CITY OF ALBUQUERQUE

**RE: Valle Prado Subdivision, Units 4 and 5
Tr 6, The Trails Unit 3A
Drainage Report Stamp Date: 2/15/19
Grading Plan Stamp Date: 2/15/19
Hydrology File: C09D011**

Based on the submittal received on 2/15/19 the above-referenced Drainage Report and Grading Plan cannot be approved for Preliminary Plat, Grading Permit or Work Order until the following are corrected:

EXHIBIT B
PROPOSED BASIN MAP

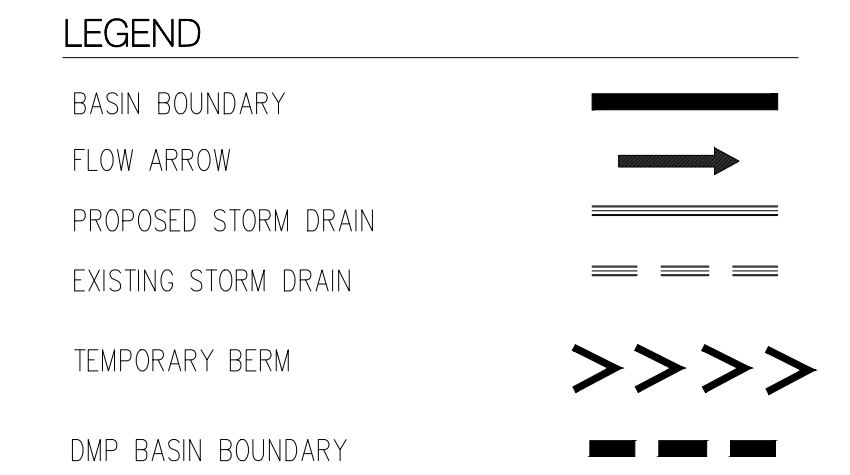
5. This project requires an ESC Plan, submitted to the Stormwater Quality Engineer (Curtis Cherne PE, ccherne@cabq.gov or 924-3420). We have old ESC Plans for Units 1-3, but nothing for Units 4-5.
6. Show the storm drain on the new subbasin exhibit (layer may be turned off or missing).
7. For Information. Prior to Unit 4 ROFG, a temporary drainage easement on the temporary ponds will be needed, unless the upstream road portions have been built.

EXHIBIT C
PHASE 4 GRADING PLAN

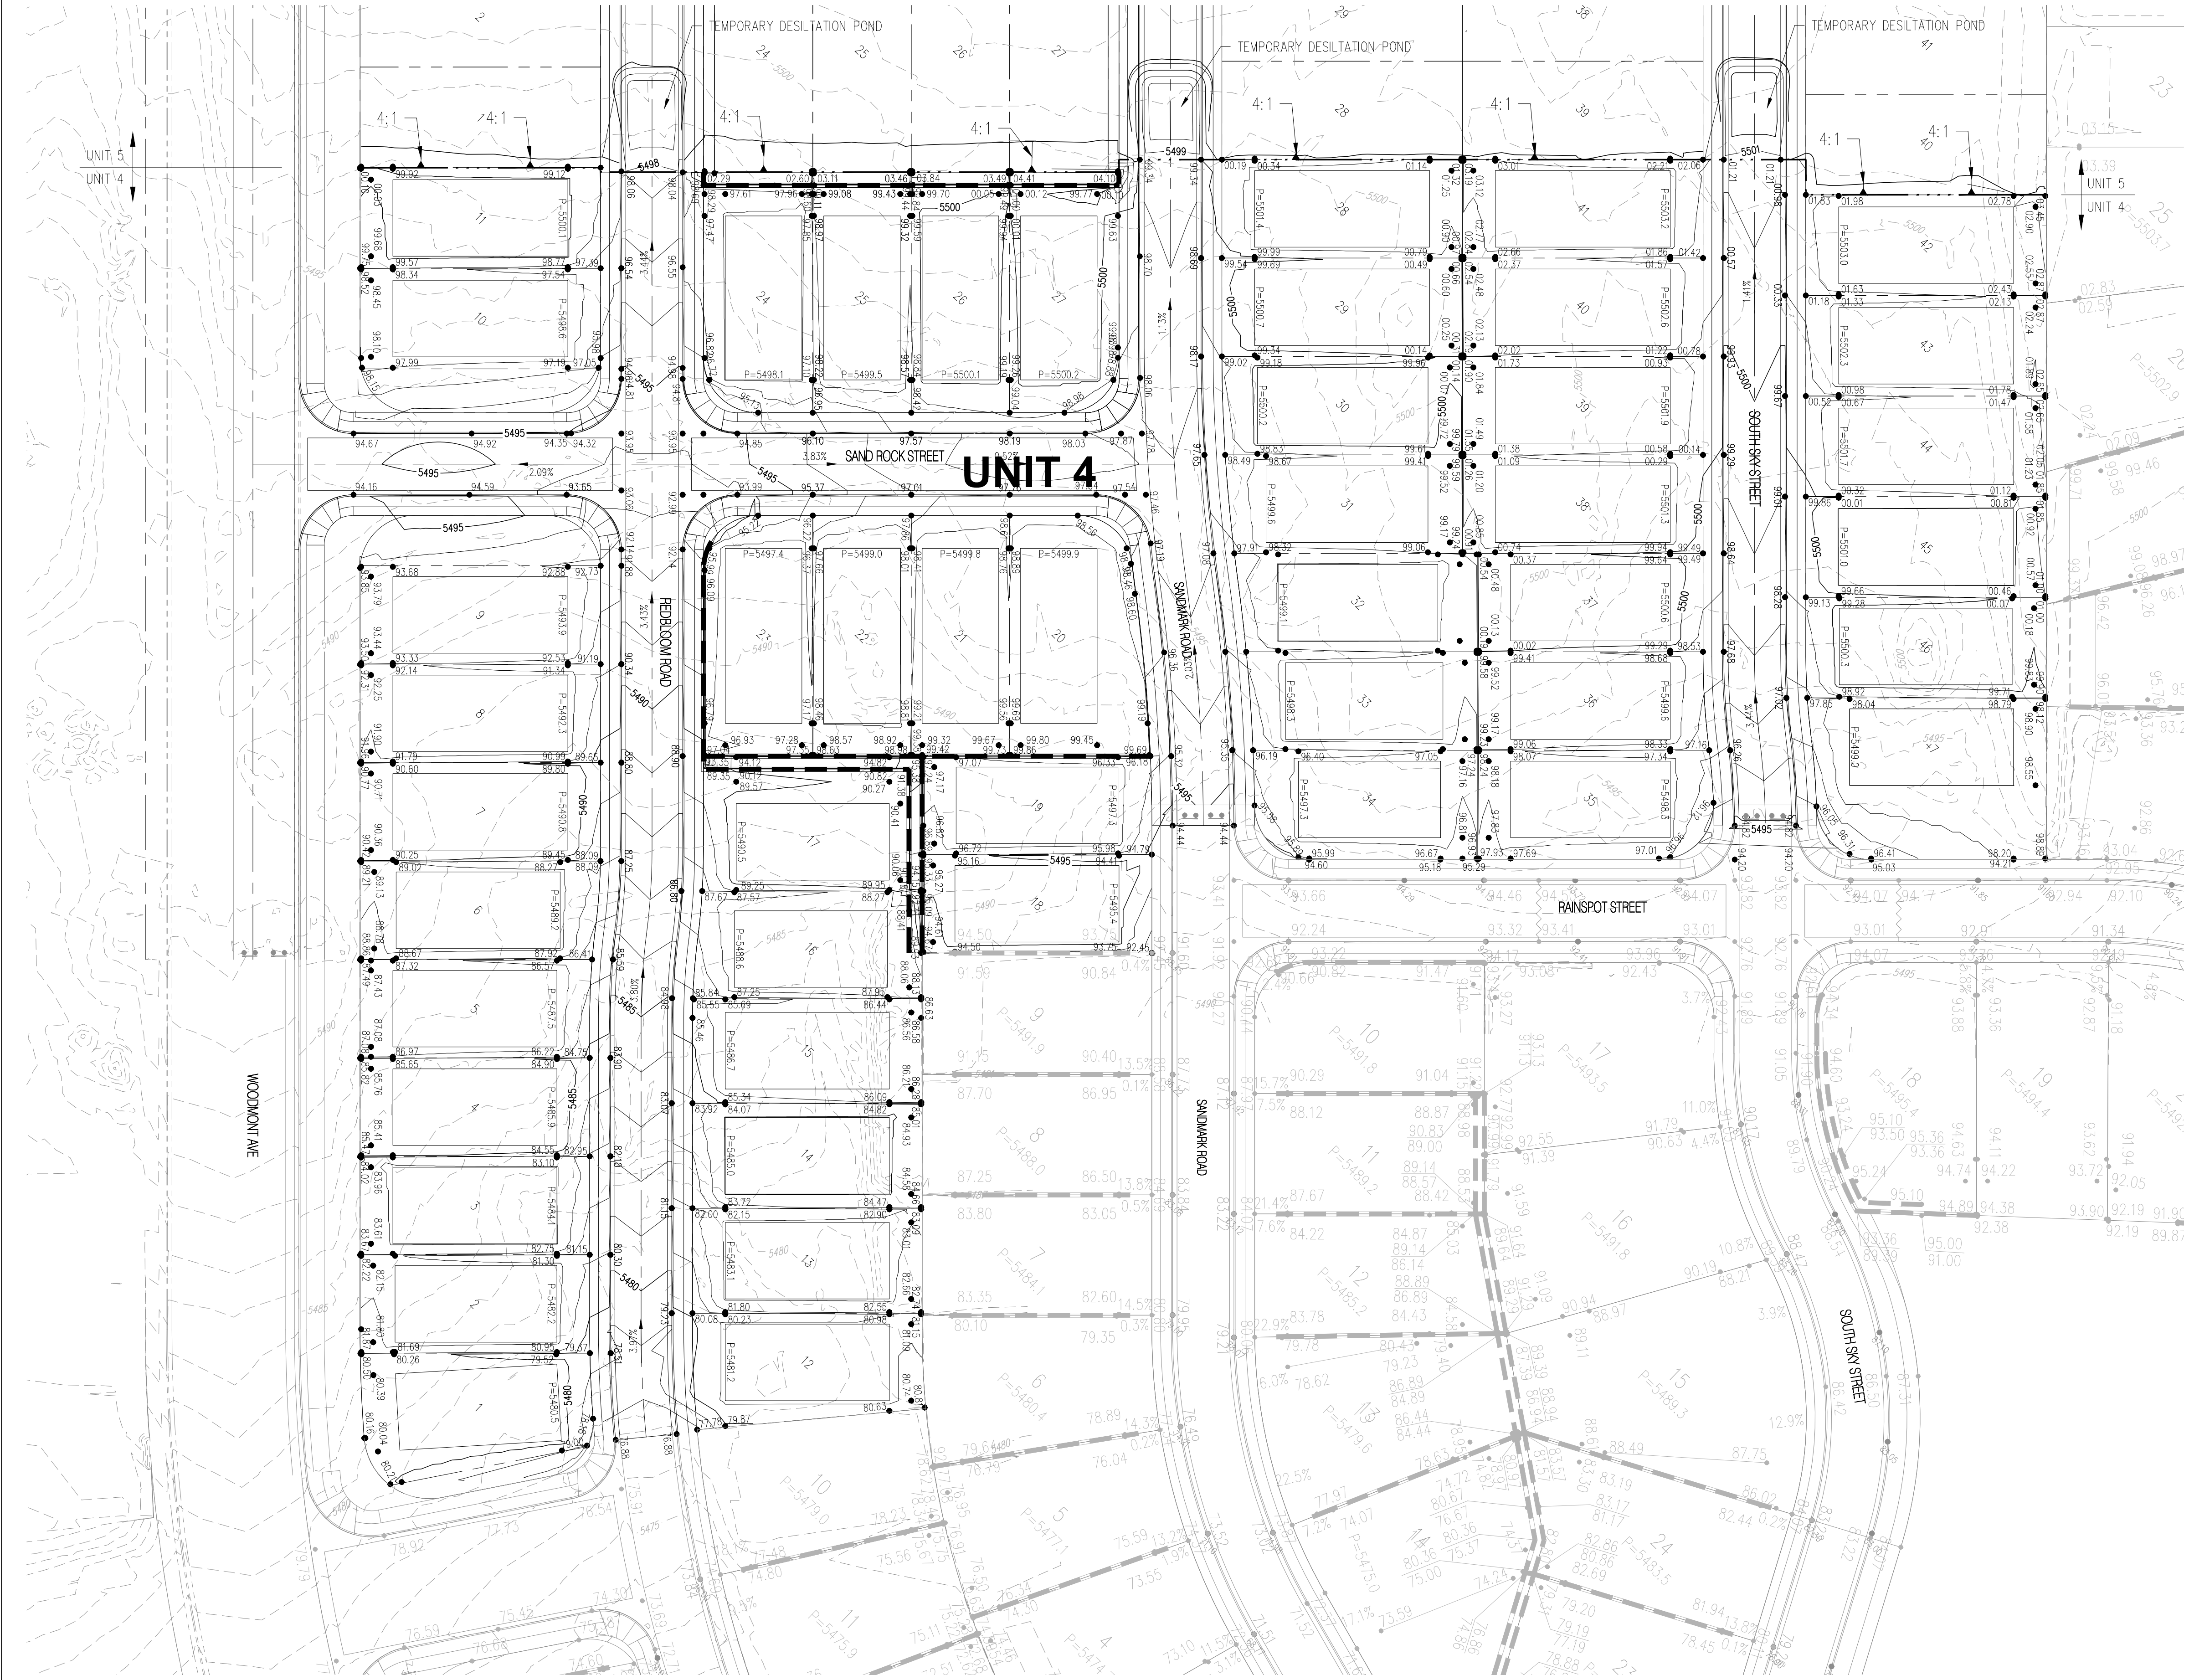
1. The Basin B and Basin C delineations are not supported by the grading plan in the vicinity of Sandmark Rd/Two Rock Rd intersection; remove the valley gutter and add supplemental spot elevations and quarter points to show the flows in the Two Rock half street will turn south and go down Sandmark instead of continuing on Two Rock.

3. The interim ponds on OS-2 should be named on the infrastructure list for Unit 4, along with drainage covenants and drainage easements. Delineate the areas draining to them and size for the 100-yr, 10day storm volume. Basin delineations are missing and the areas don't appear to reflect the entire area draining to the ponds; another interim pond seems necessary just north of the South Sky/Two Rock intersection.

EXHIBIT D
PHASE 5 GRADING PLAN

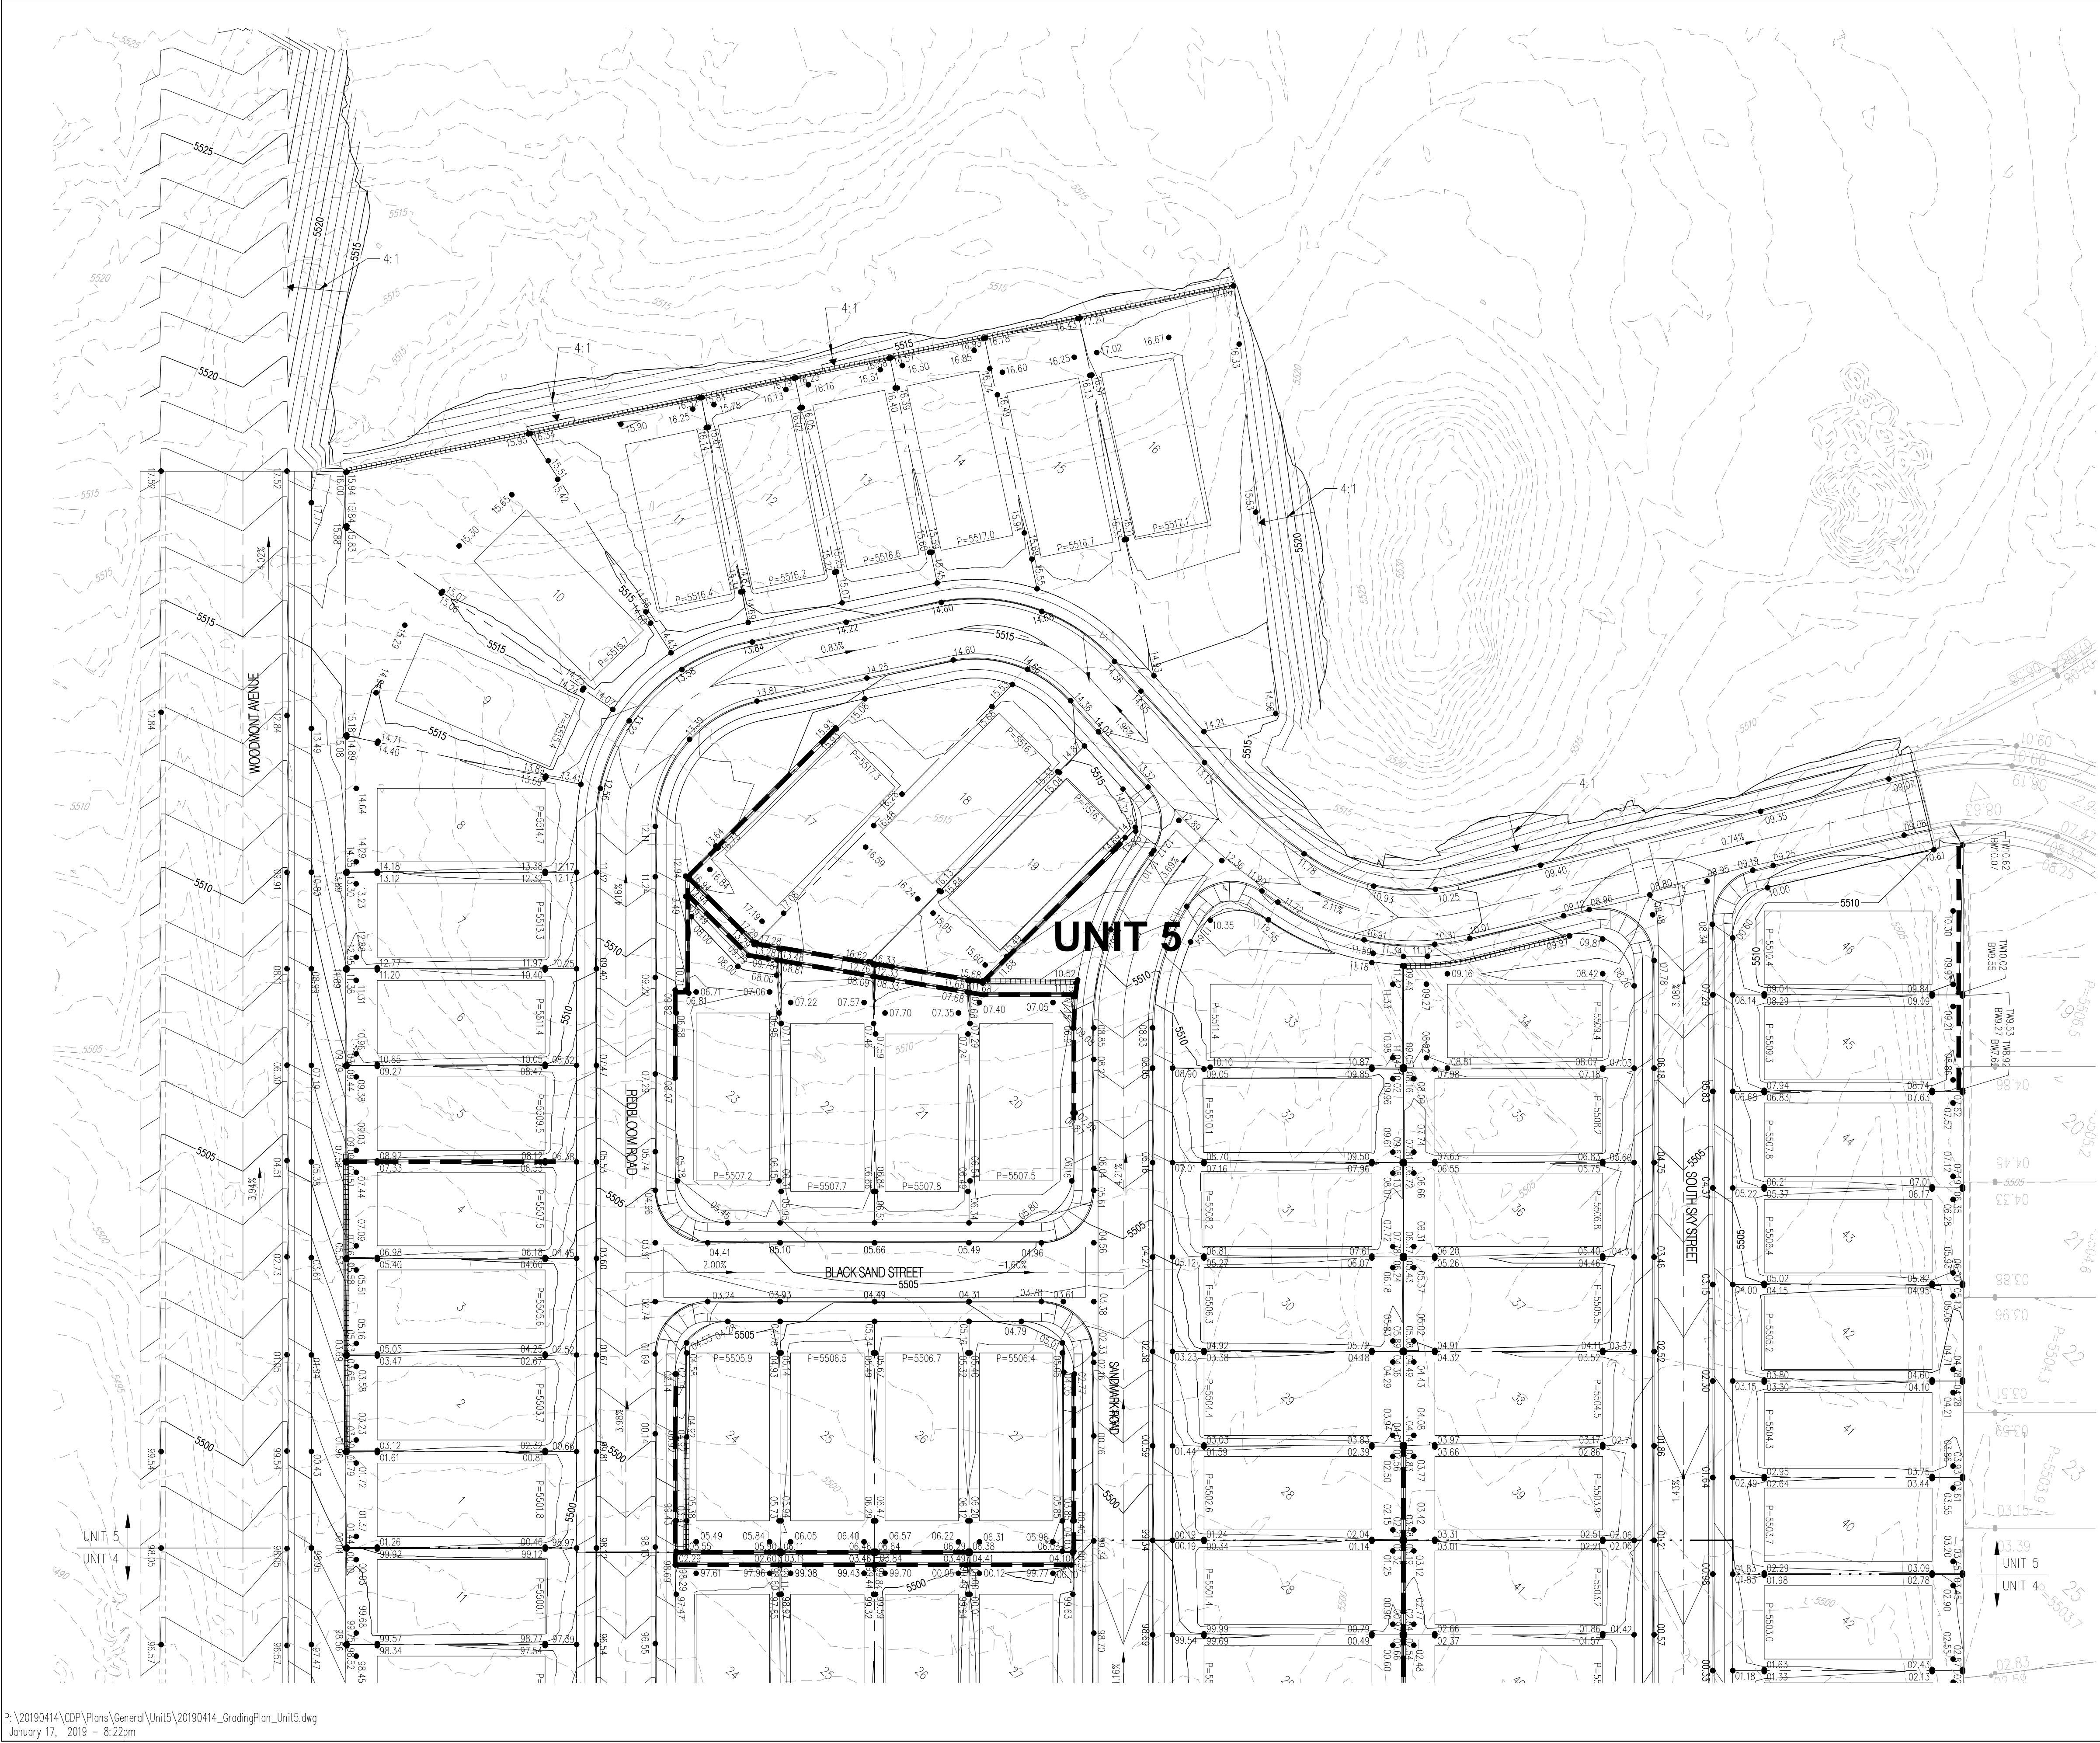
2. Provide written and signed permission from the owner of Tract OS-2 for the grading on their property (along the north side of Valle Prado Unit 5). If the retaining wall behind lots 10-16, Unit 5 will encroach, you should get this permission as well.
